Whalley Parish Council

PLANNING APPLICATIONS

Yours Sincerely,

Proposed Site & Ground Floor Plan

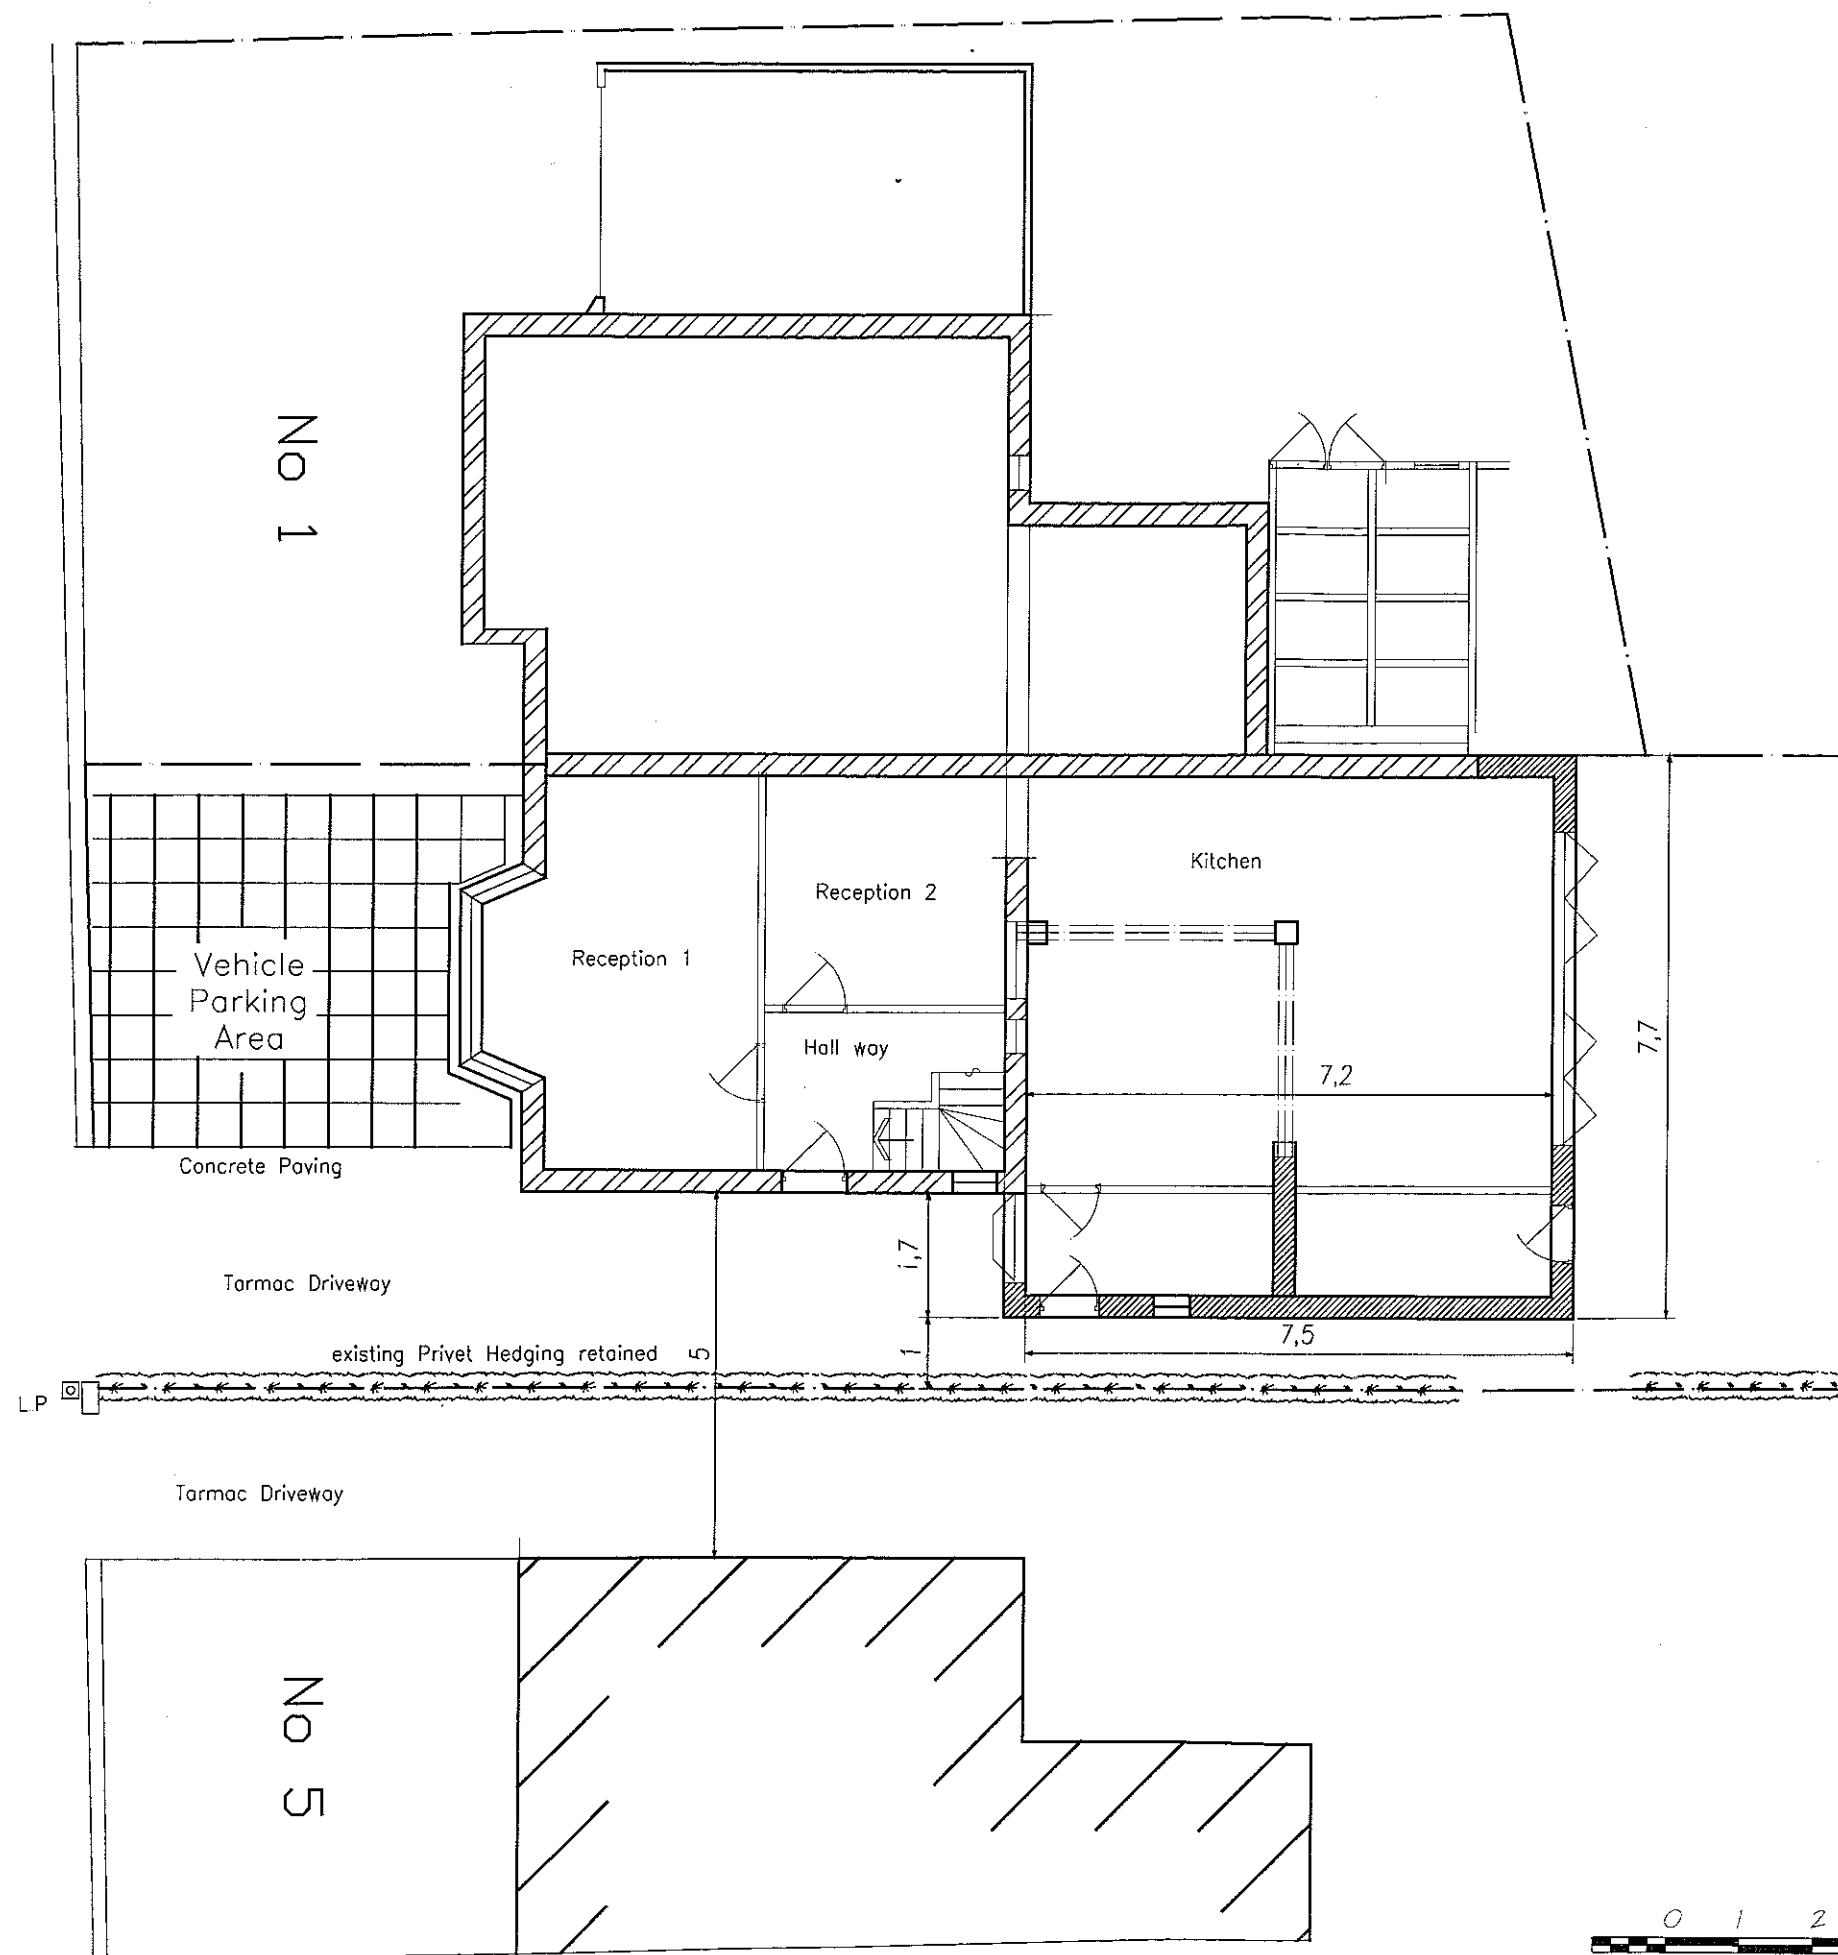
3/2012/0202	Proposal:	Application to discharge condition no 4 (materials)
	Location:	21 Clitheroe Road Whalley BB7 9AA
	No Observations	
3/2012/0226 tree works 9SN	Proposal:	Crown lift and crown thin three trees. Application for
	Location:	Whalley Methodist Church King Street Whalley BB7
	No Observations	
3/2012/0181	Proposal:	Two storey extension
	Location:	3 Woodlands Drive Whalley BB7 9HL
	Observation	The parish council question the extent and proportion of the proposal and the impact on the neighbouring property
3/2012/0246 additional bedroom space / en-suite and window to the side gable/ side extension to the rear to create a utility room.	Proposal:	New extension to the front elevation to create
	Location:	13 Abbots Croft Whalley BB7 9RR
	Observation	The parish council express concern that the front elevation of the property will extend beyond the existing building line.
